SSD 35999468 - Shoalhaven Hospital Redevelopment
Lot 104 DP 1165533, Lot 7034 DP 1031852 & Lot 373 DP 755952
Shoalhaven St, NOWRA

Please find below technical comments from Council on the Request for Advice in relation to the submitted Environmental Impact Statement (EIS) for the proposed development.

SHOALHAVEN ST DROP-OFF OPTIONS

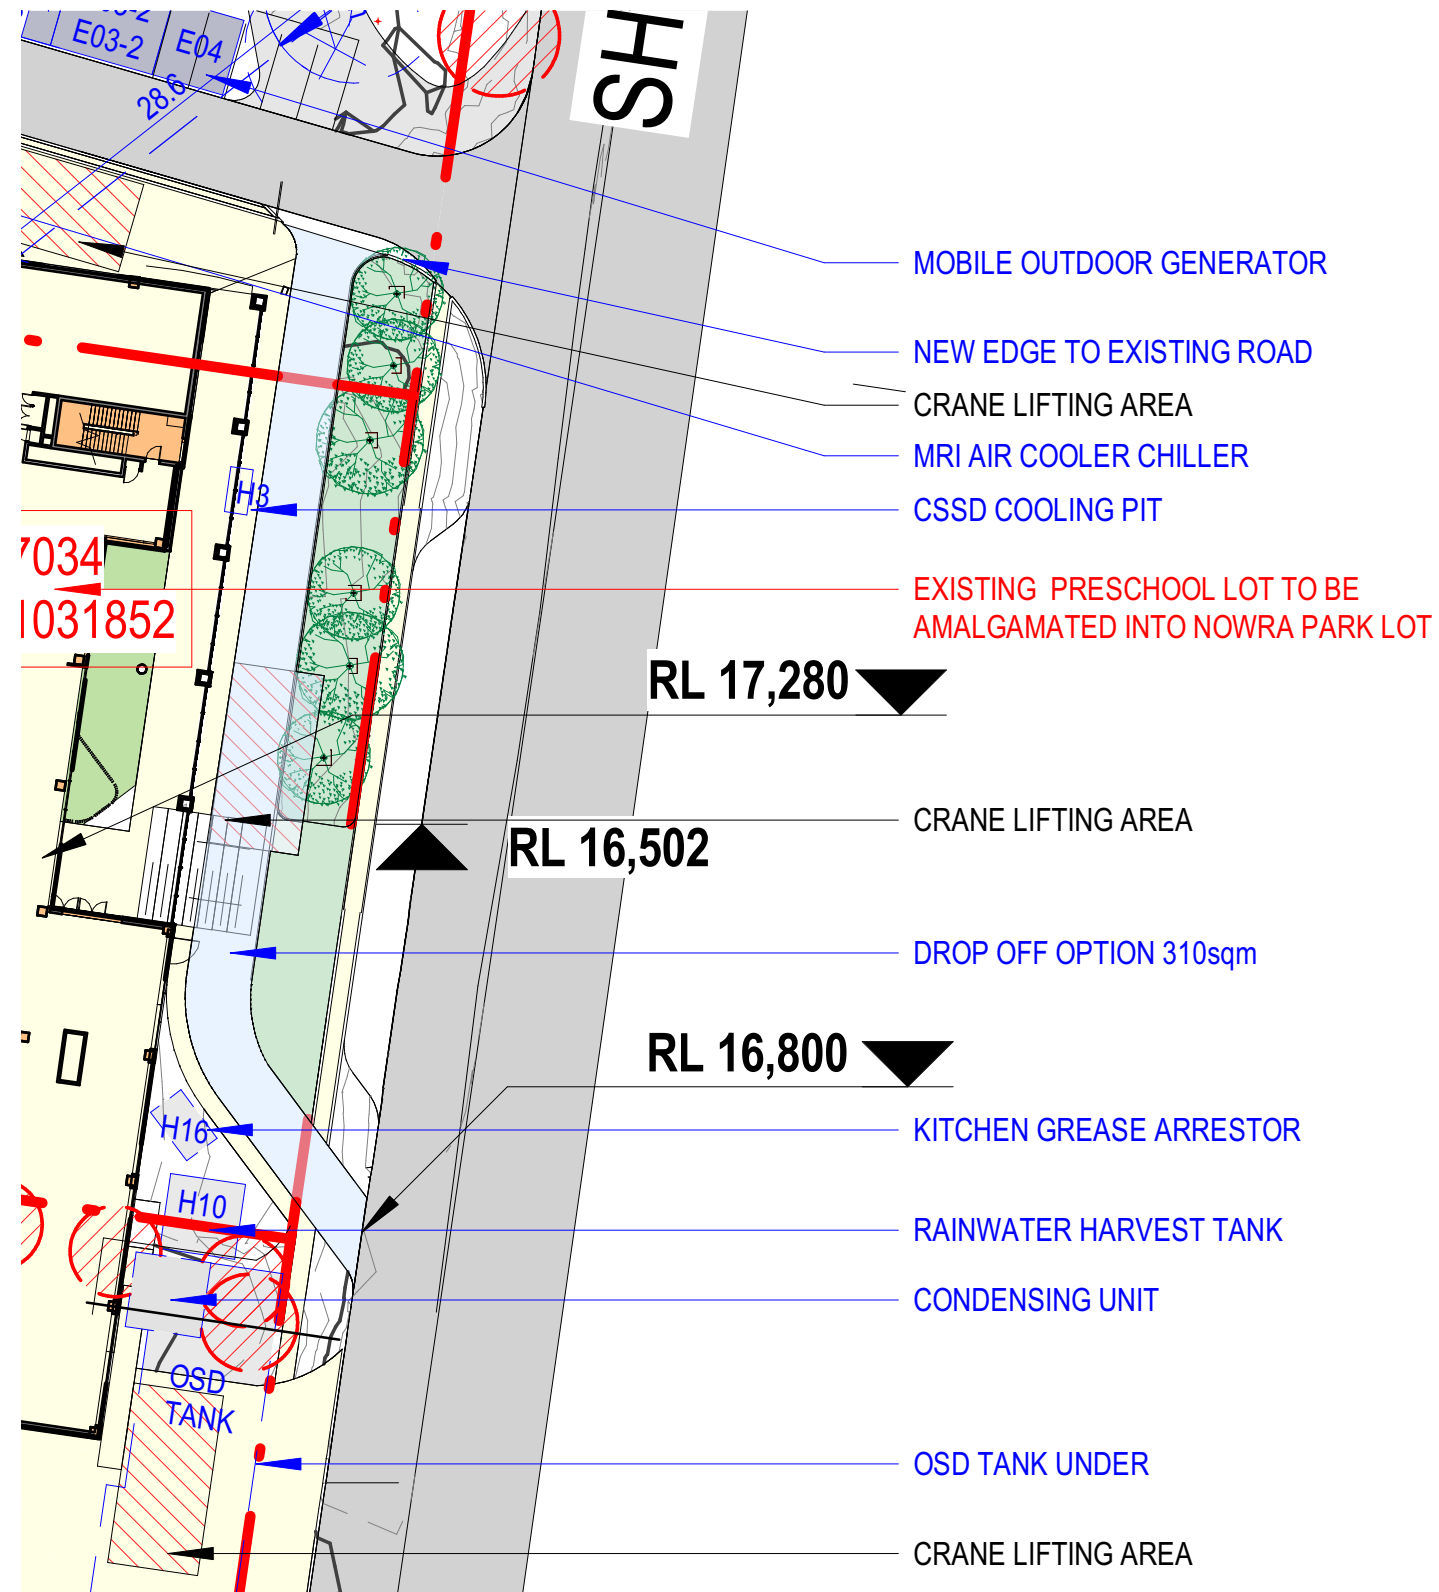
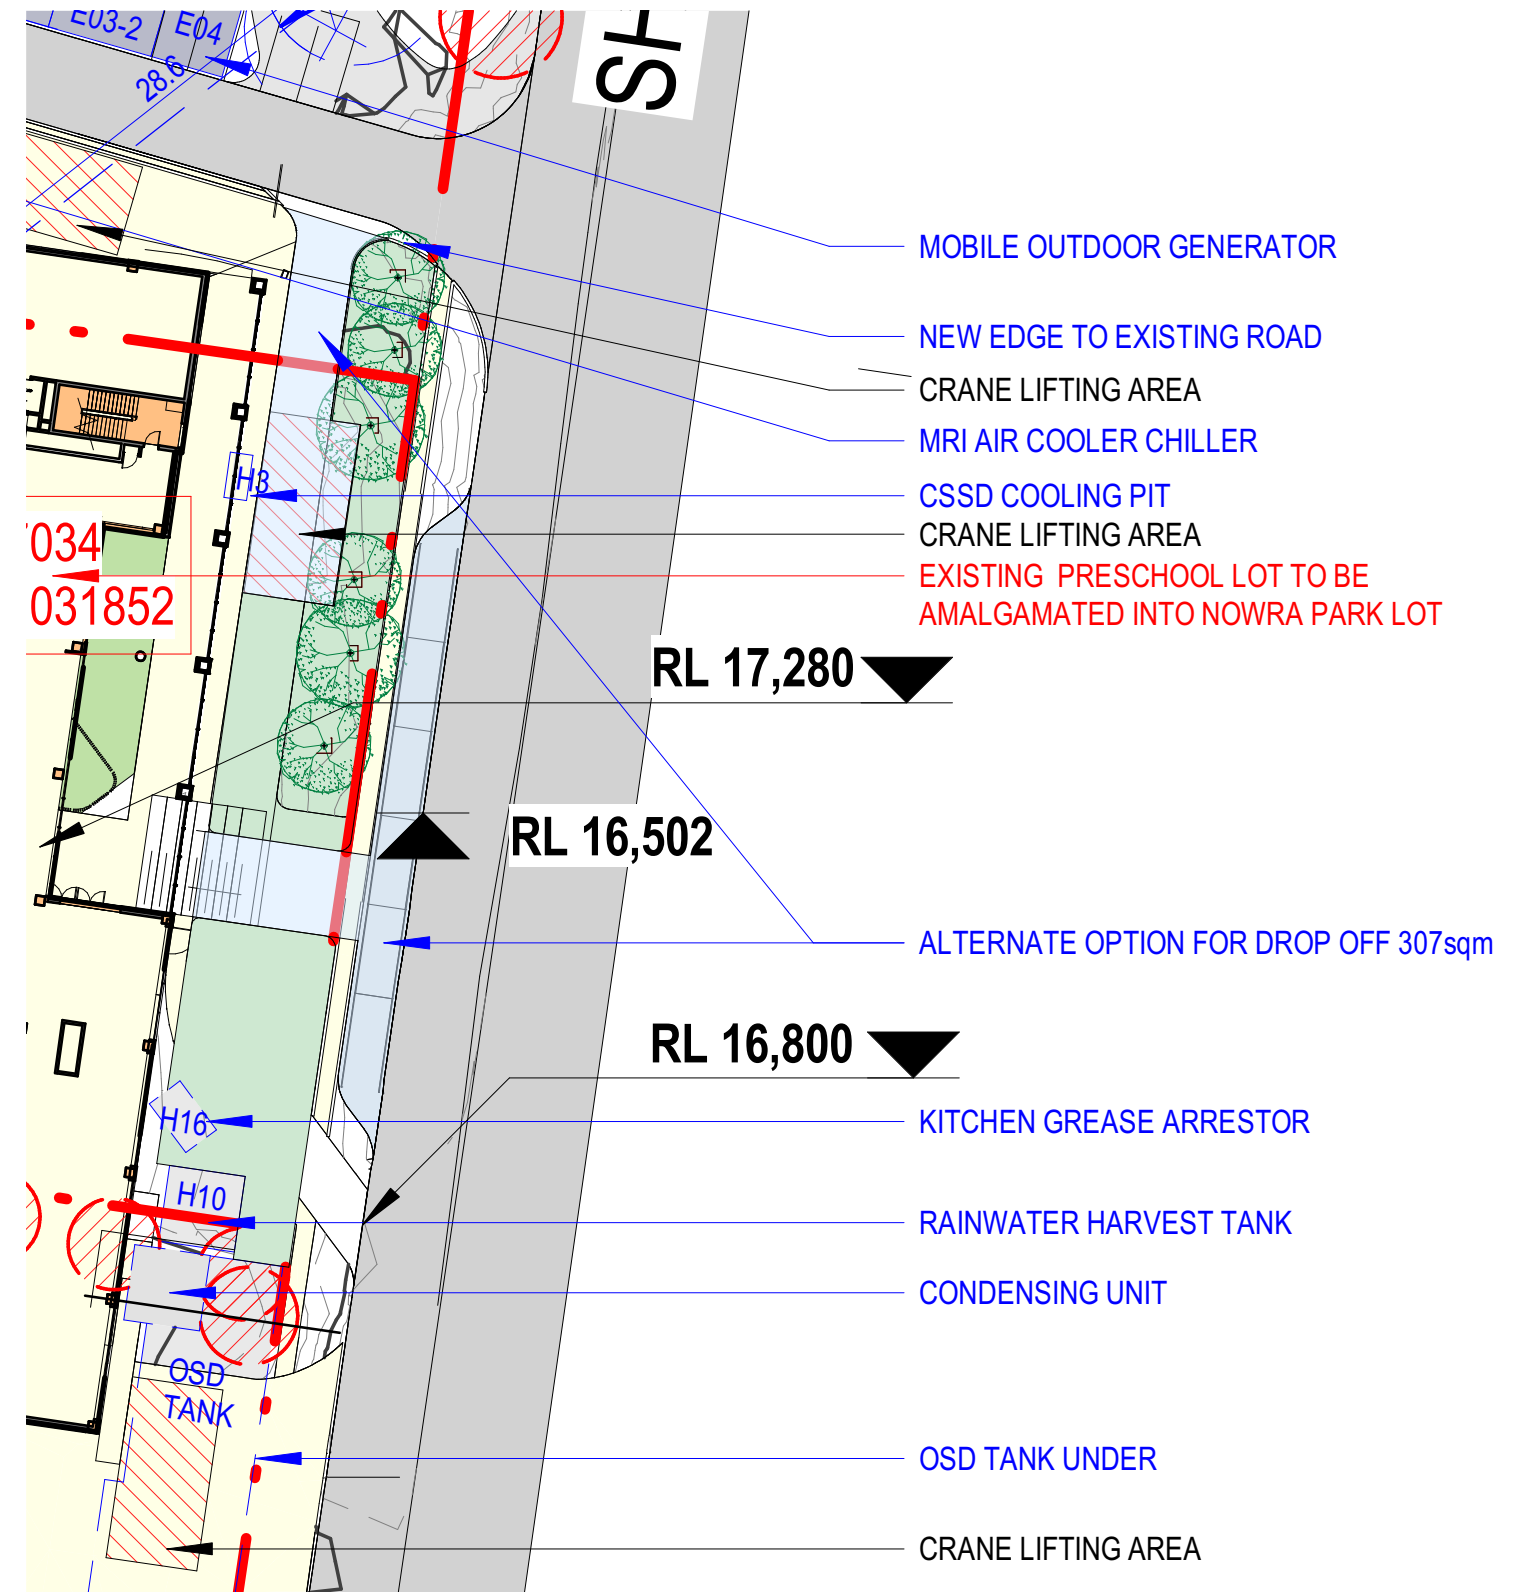
- The proposed lane for passenger pick up/drop off is not considered appropriate as passing parked vehicles is not possible. The access on to the internal road is also too close to the public road and may cause conflict and be potentially dangerous.
- The use of decomposed granite within the site for footpaths is not considered appropriate nor a long-term solution. This would likely scour out and create issues for users with mobility issues, cause trip hazards.
- A concrete footpath would be required to be installed along the entire frontage of the development and connect to existing pedestrian pathways. As currently shown, they are not continuous.
- A pedestrian refuge should be incorporated at the main entry driveway on North Street due to the driveway width proposed.

DESIGN DEVELOPMENT
Drawing Name
**Landscape Plan
Ground Level**
Scale 1:100 @ A1
Job Number
SS20-4580
Drawing Number
1 2 3 4 5m
Issue
103 F

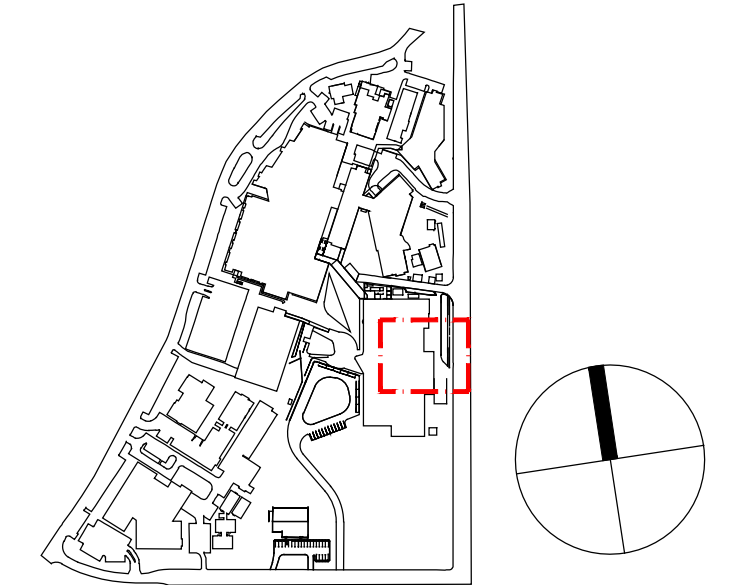
- There appears to be an opportunity to install some additional seating (i.e. standalone or incorporated into landscaping) around the landscaped area surrounding the large blackbutt tree for the use of the public and staff for use during lunchbreaks.
- Given the amount of outstanding issues and the incomplete consultation conducted as part of the Transport and Accessibility Impact Assessment, Council is not satisfied with providing engineering conditions at this stage as it is believed that many issues remain outstanding and unresolved.
